From: Jeff Smith <Jeffrey.Smith@endeavourenergy.com.au>
Sent: Thursday, 8 July 2021 9:30 AM
To: Grant Harlow
Subject: RE: S29/3/97-Mod-1 - Eastern Creek Karts, Departments design comments

Subject: S29/3/97-Mod-1 - Eastern Creek Karts, Departments design comments

Following on from our discussions on design requirements on 26th and 28th May 2021 for the above please see the following notes for design work :-

PLAN TO BE PRINTED IN COLOUR

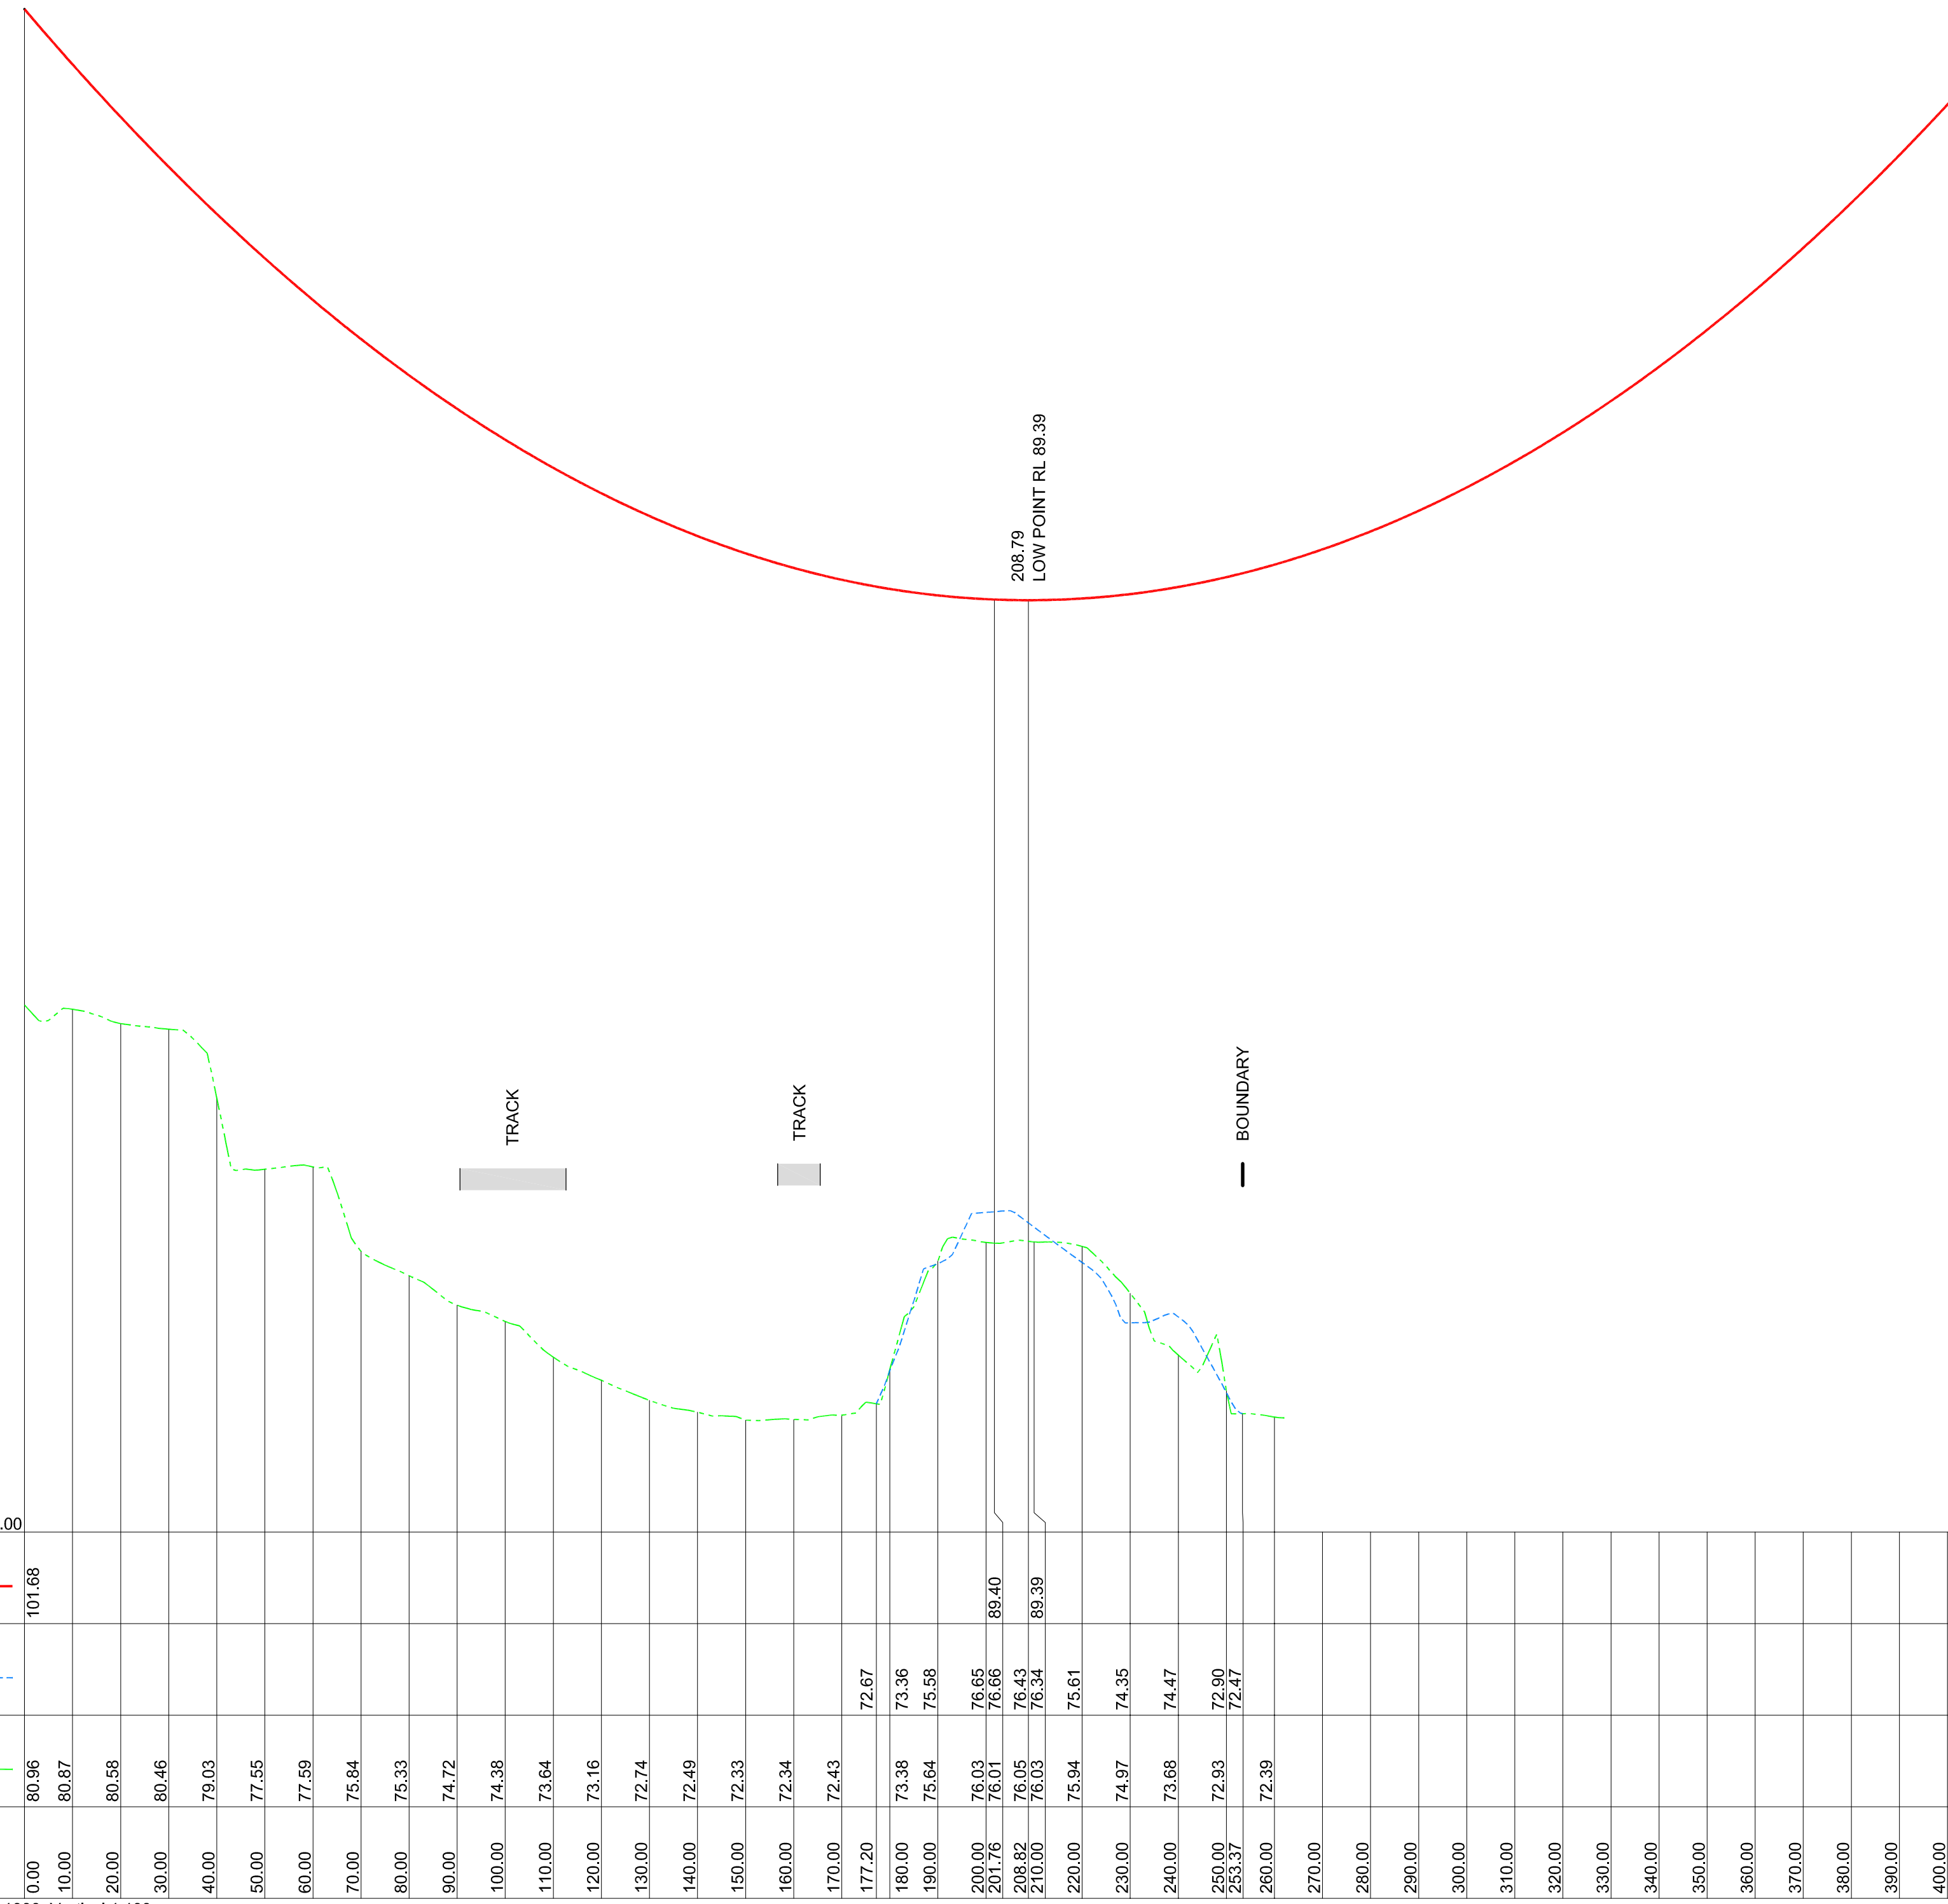
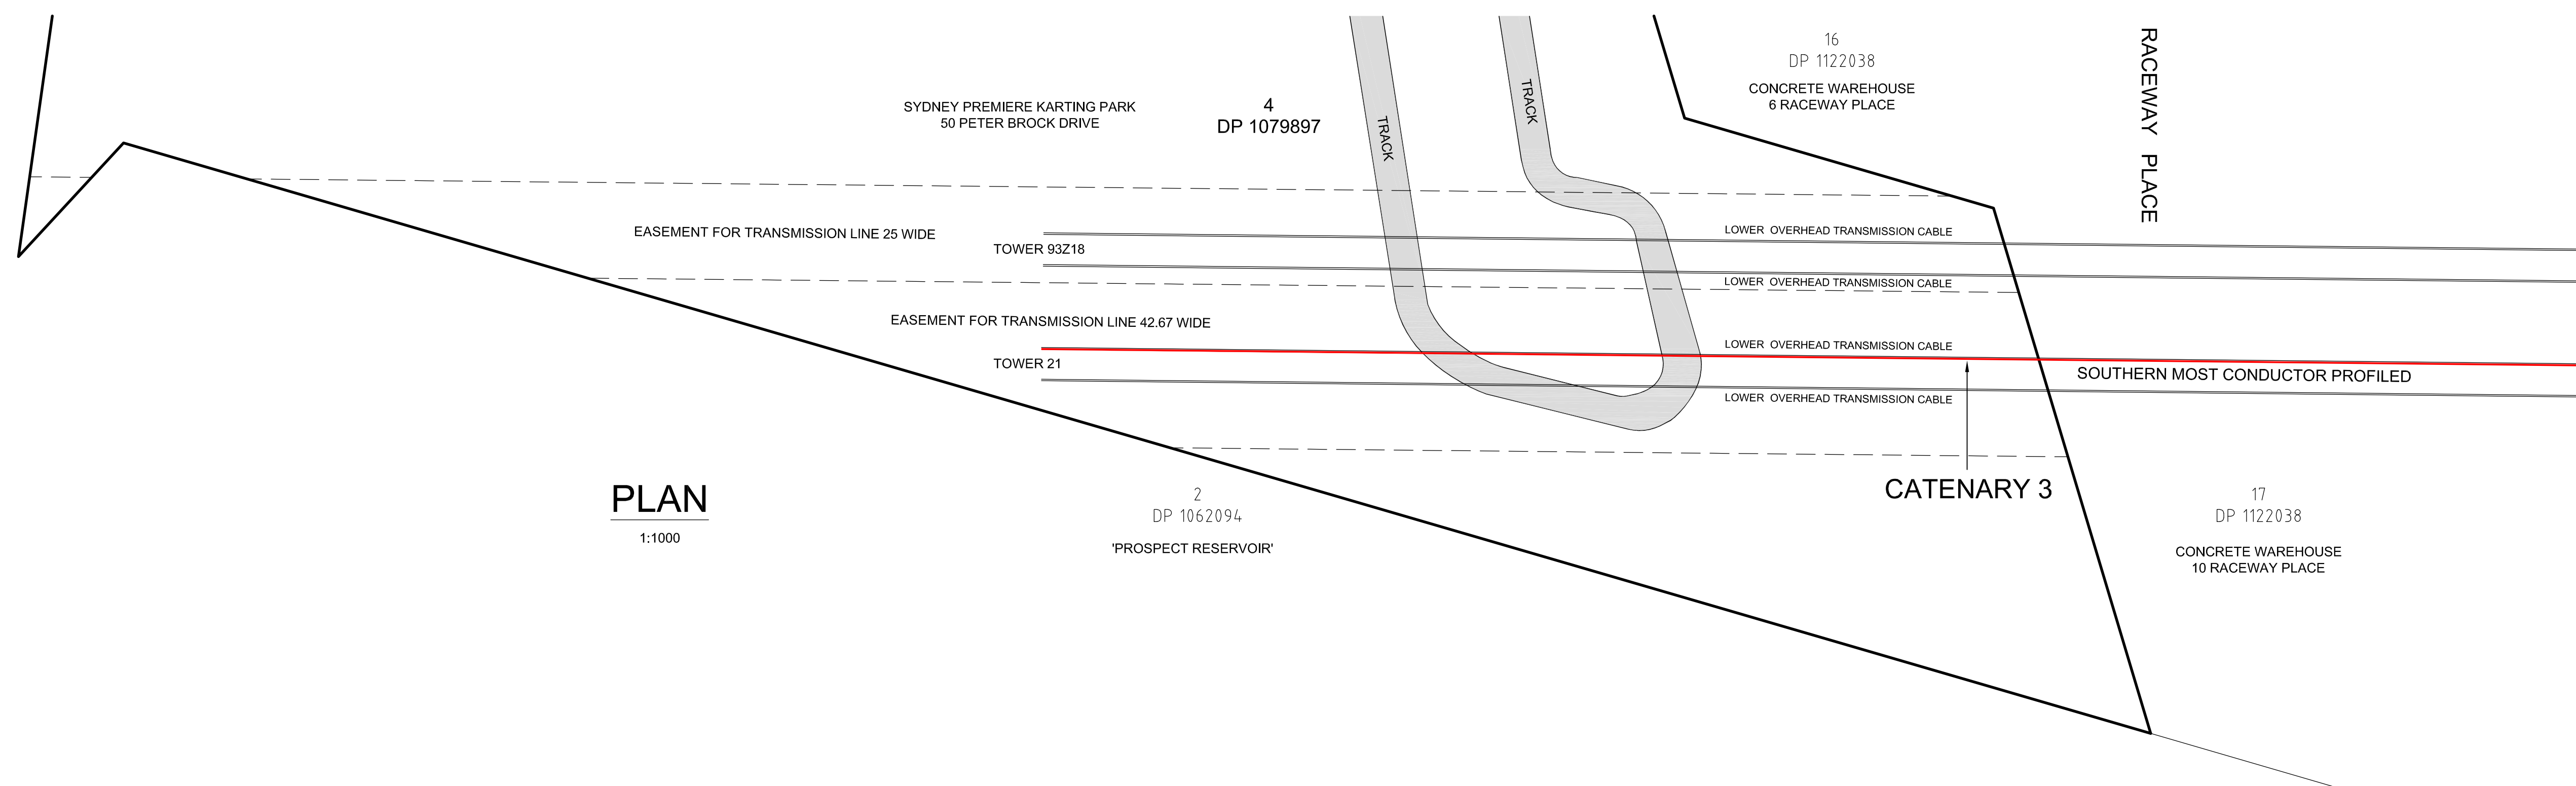
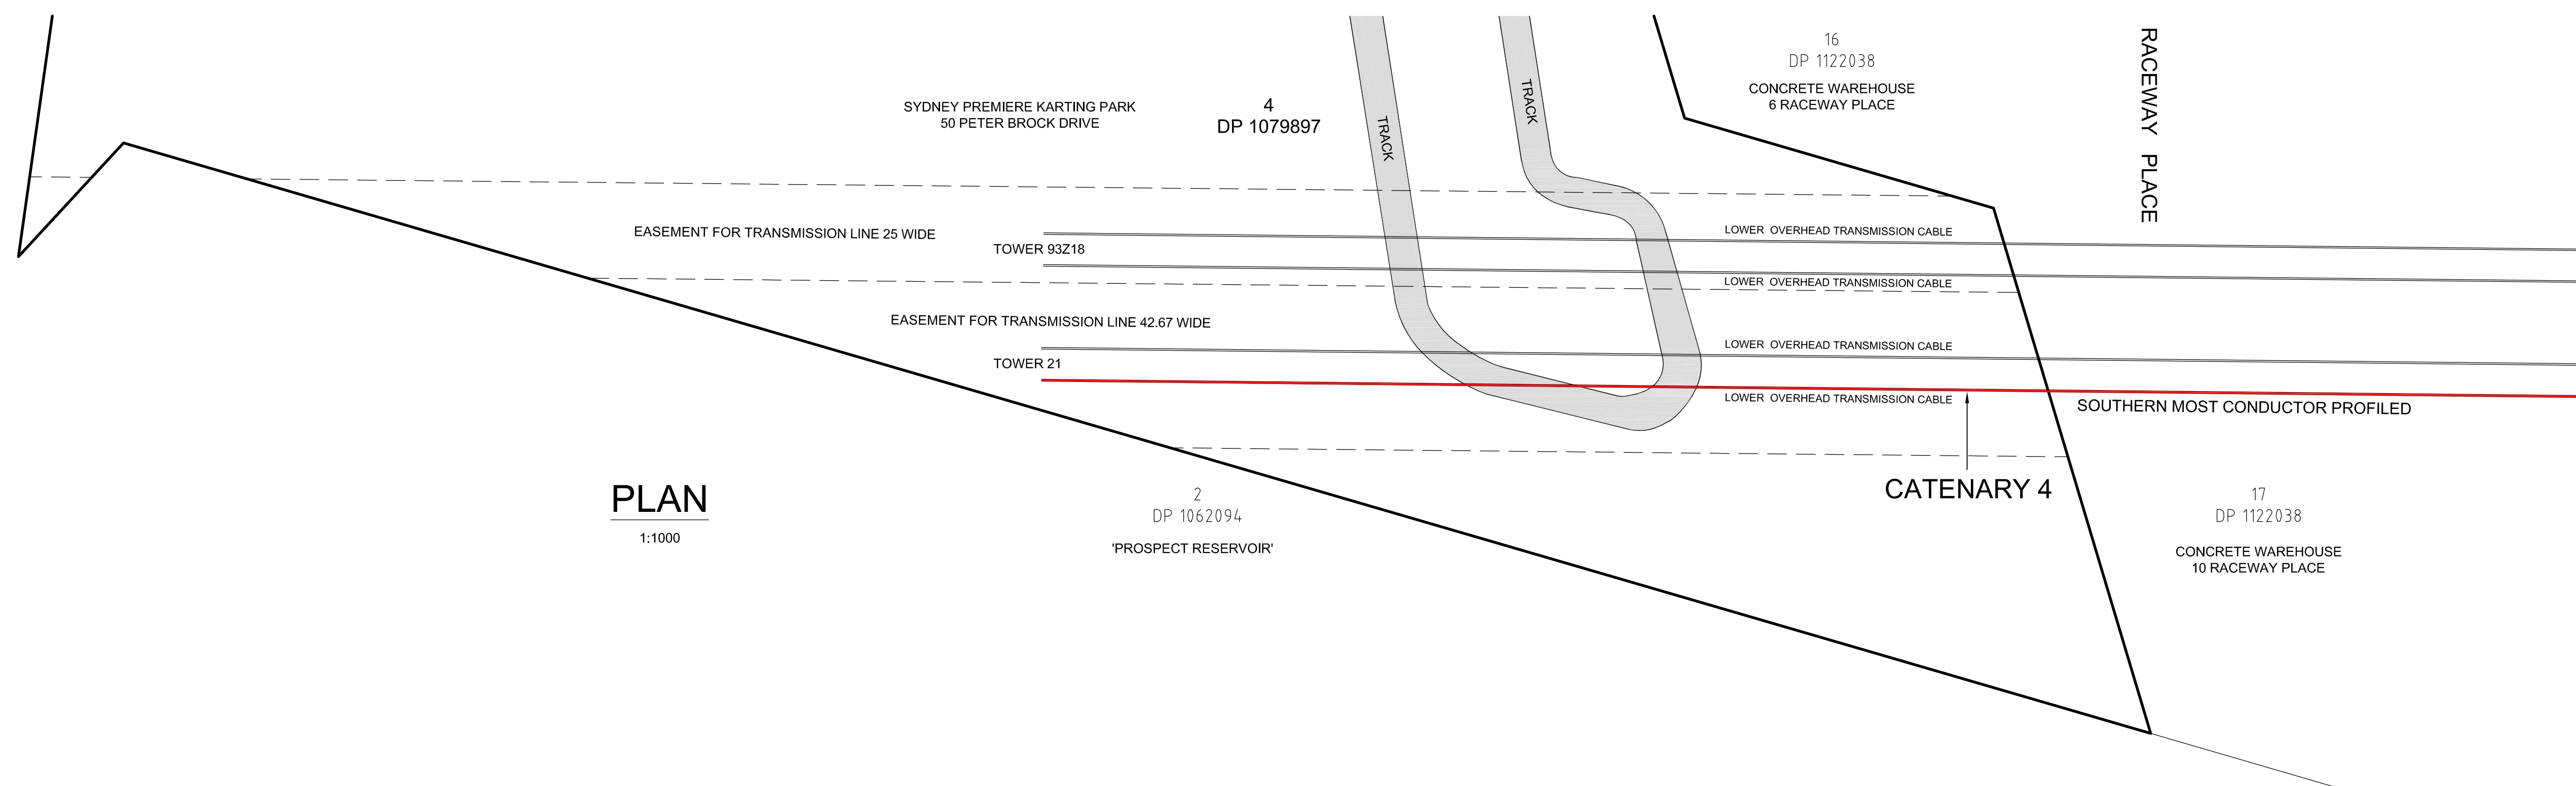
- 1) An updated Centre-Line Profile including current levels and the proposed Levels.
- 2) The 132kv Earth Potential Rise Assessment Report.

- A Centre-Line Profile, as per the requirements stipulated within *clause 6* of the General Restrictions for Overhead Power Lines.
This must include the Current Levels and the Proposed Levels.
- A 132,000 volt Earth Potential Rise Assessment Report as described in the *Electrical Hazards in Pipeline Construction* attachments.

I note that we have made some slight adjustments to the proposed carpark surface mainly for drainage reasons. These are minor and do not result in any material change to the centreline profiles previous supplied. We will however provide you with an updated set of profiles.
